MEMORANDUM

SUBJECT: SP-19-006 – Saddlehorn Ranch/824
First Submittal

Engineering Division

NOTES:

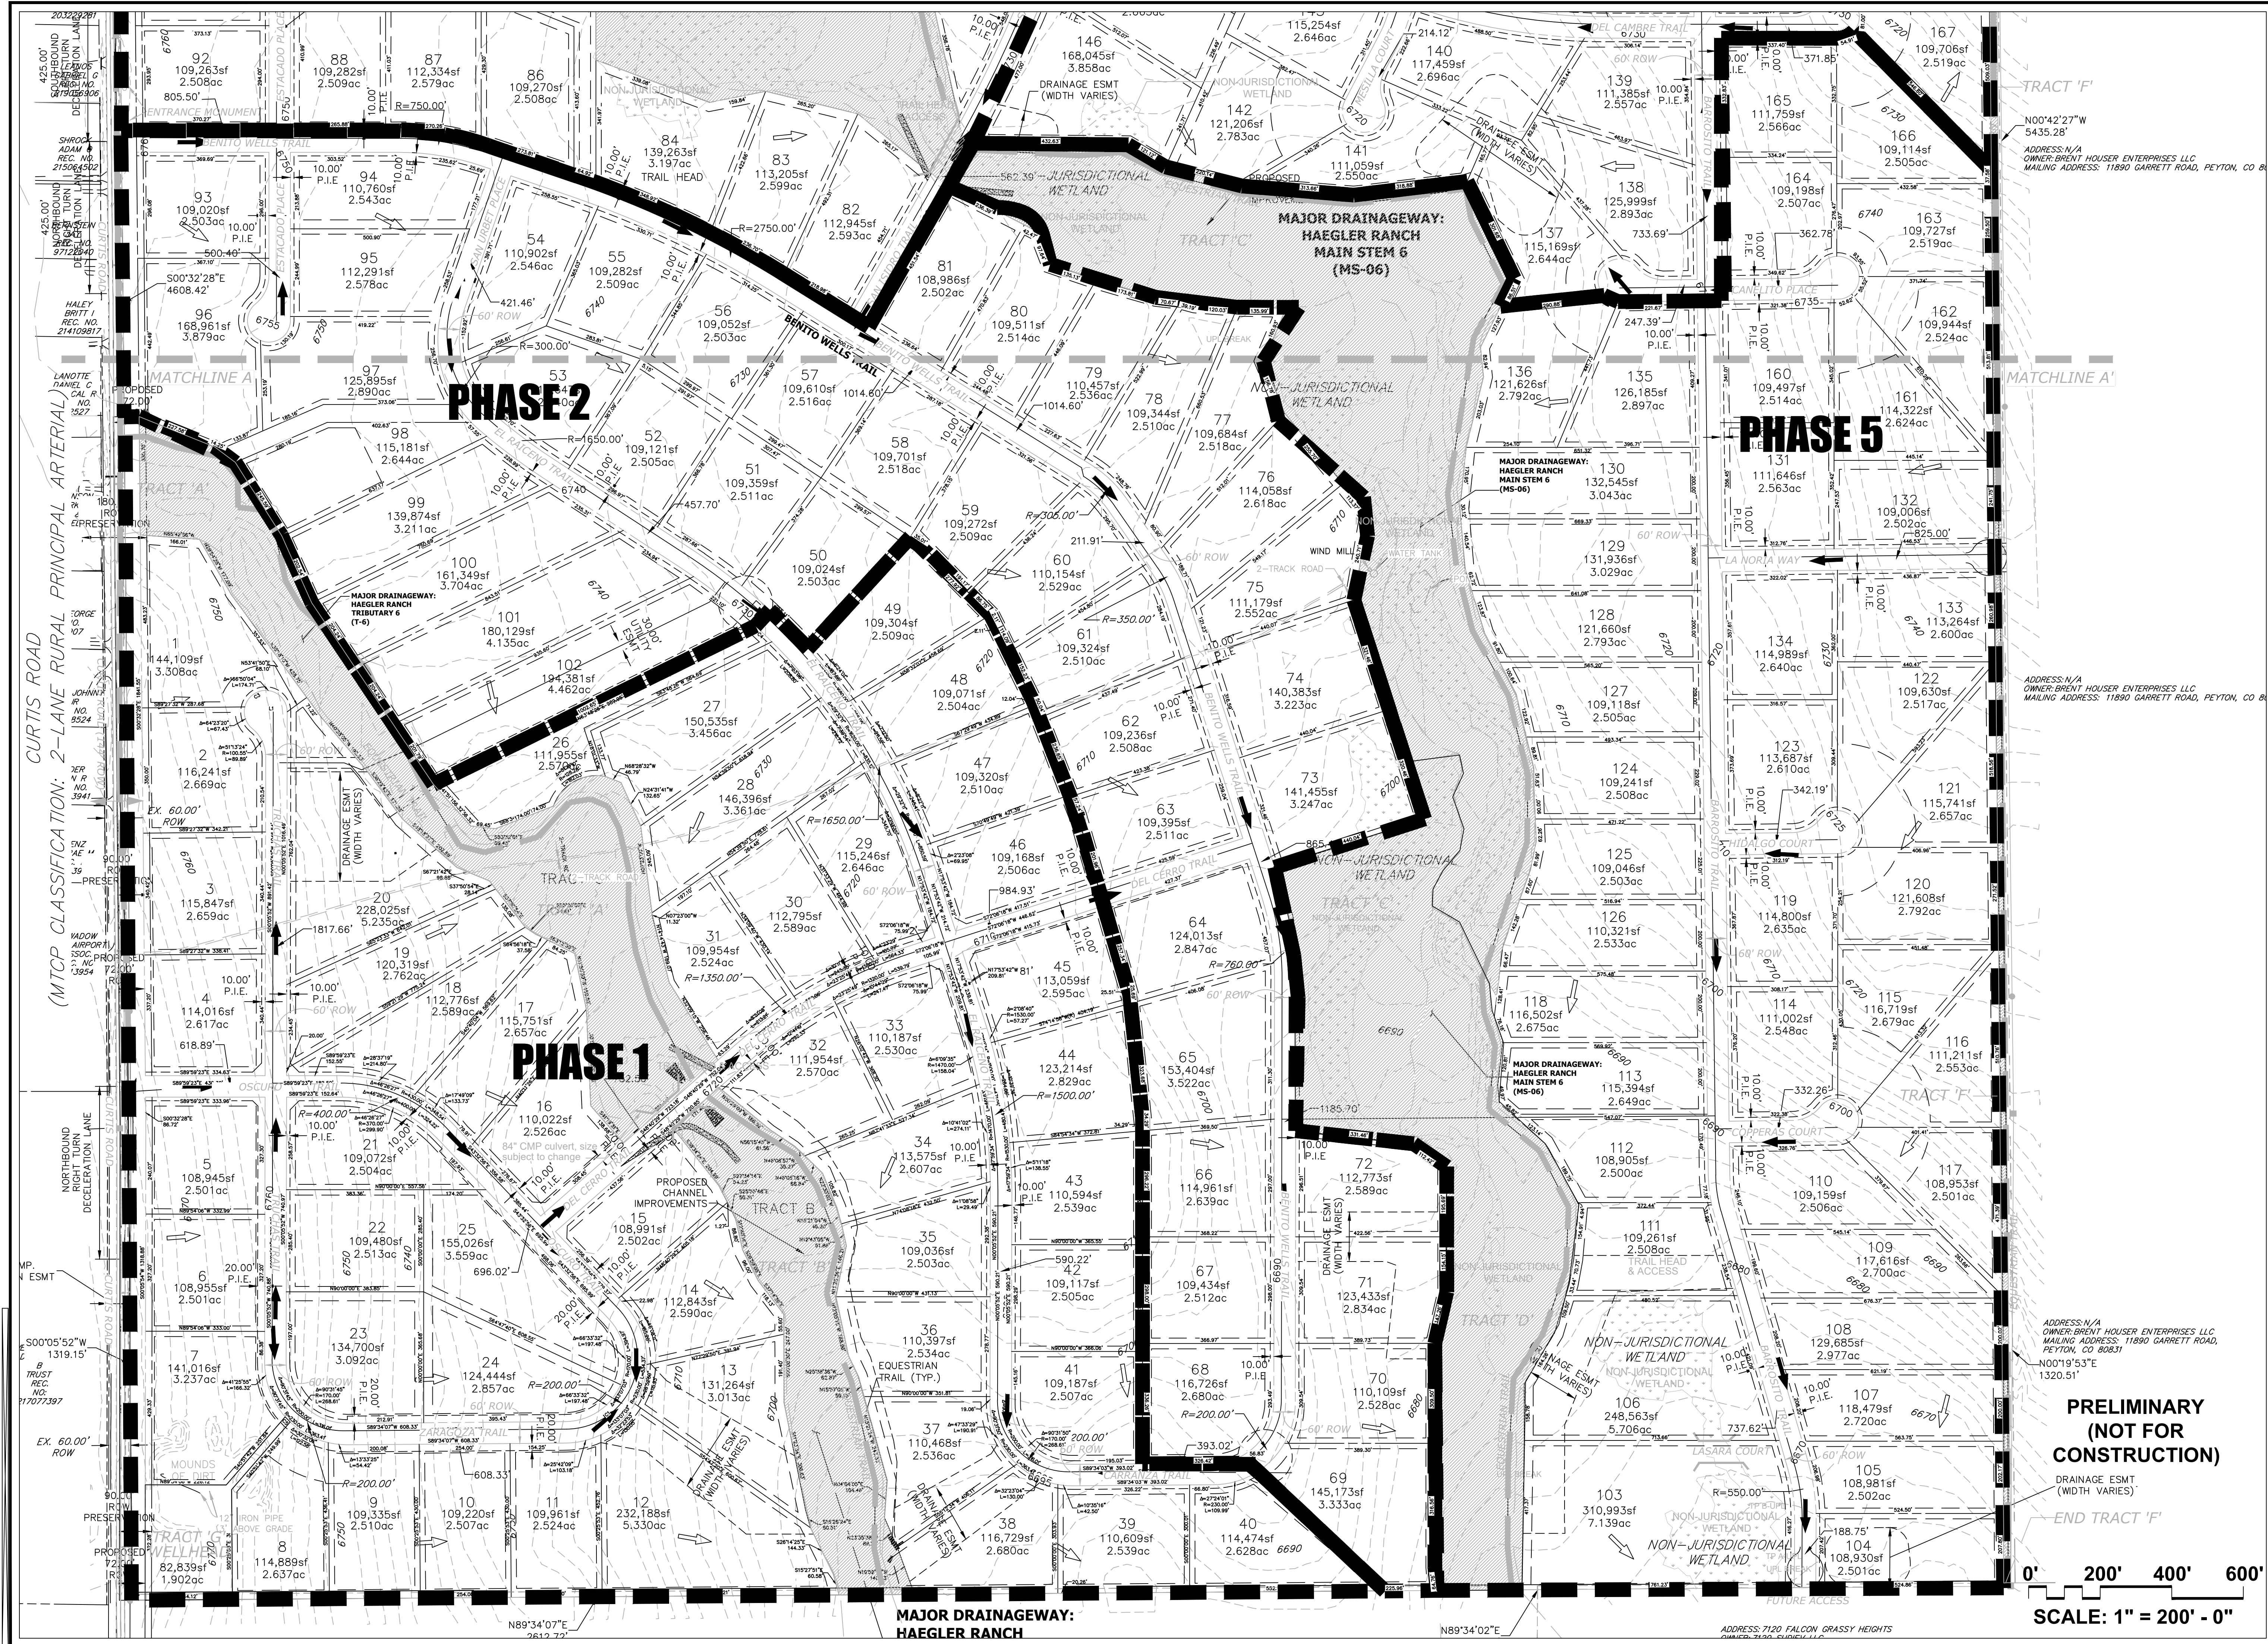
1. Label the Judge Orr Road and Curtis Road MTCP classifications, proposed rights-of-way and ROW preservation. Provide cross-sections (see TIS comment #1 below).
2. Show and label existing and proposed drainage facilities and all necessary drainage and maintenance access easements.
 - a. JR Response: Addressed.
3. Ensure that all checklist items are provided.
 - a) Guman response: checklist items provided.
4. Provide a note stating that approved Base Flood Elevations (BFEs) are required to be obtained for any plats in or within 300 feet of the northeast corner.
 - a) Guman response: This is called out on General note 18 on the cover sheet.
5. See preliminary plan redlines for additional comments.
 - a) Guman response: Redlined changes have been incorporated.

CURTIS ROAD - MODIFIED MINOR RURAL ARTERIAL - INTERIM FUTURE

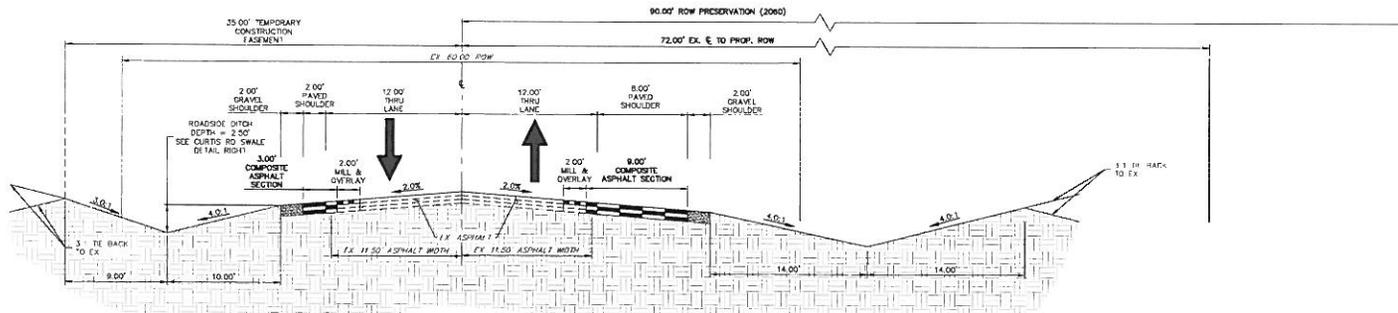
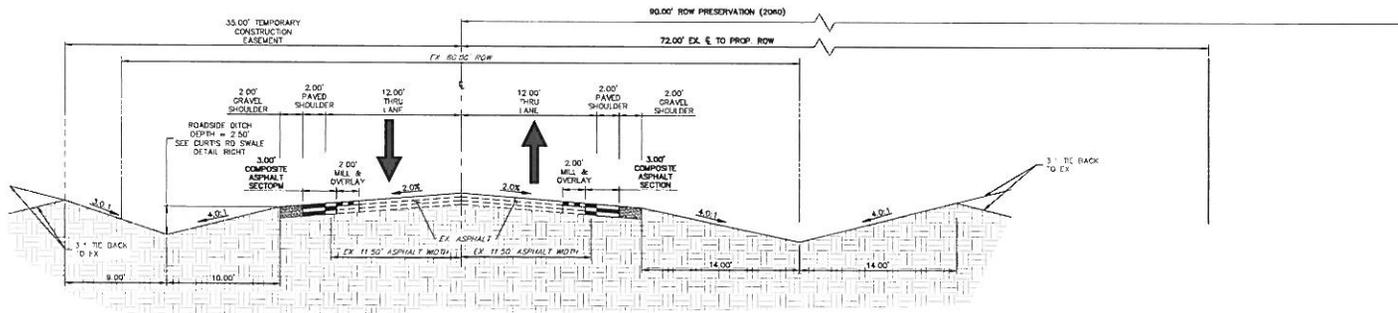
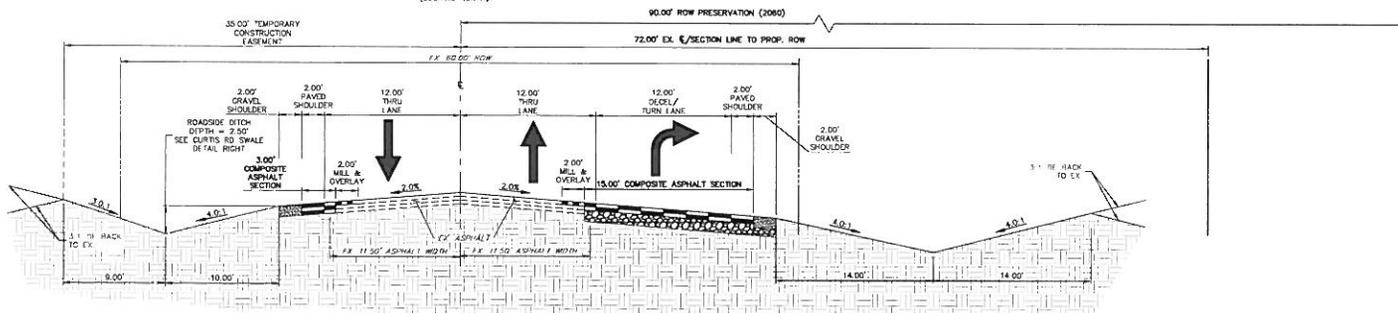
1. Provide deviation requests for the proposed Curtis Road and Judge Orr Road cross-sections to set the required widths going forward on this project (see e-mail dated April 3, 2019) The deviation requests need to address where there is not a defined cross-section in the ECM. This is needed to document acceptance of the cross-sections and track potential ECM revisions.
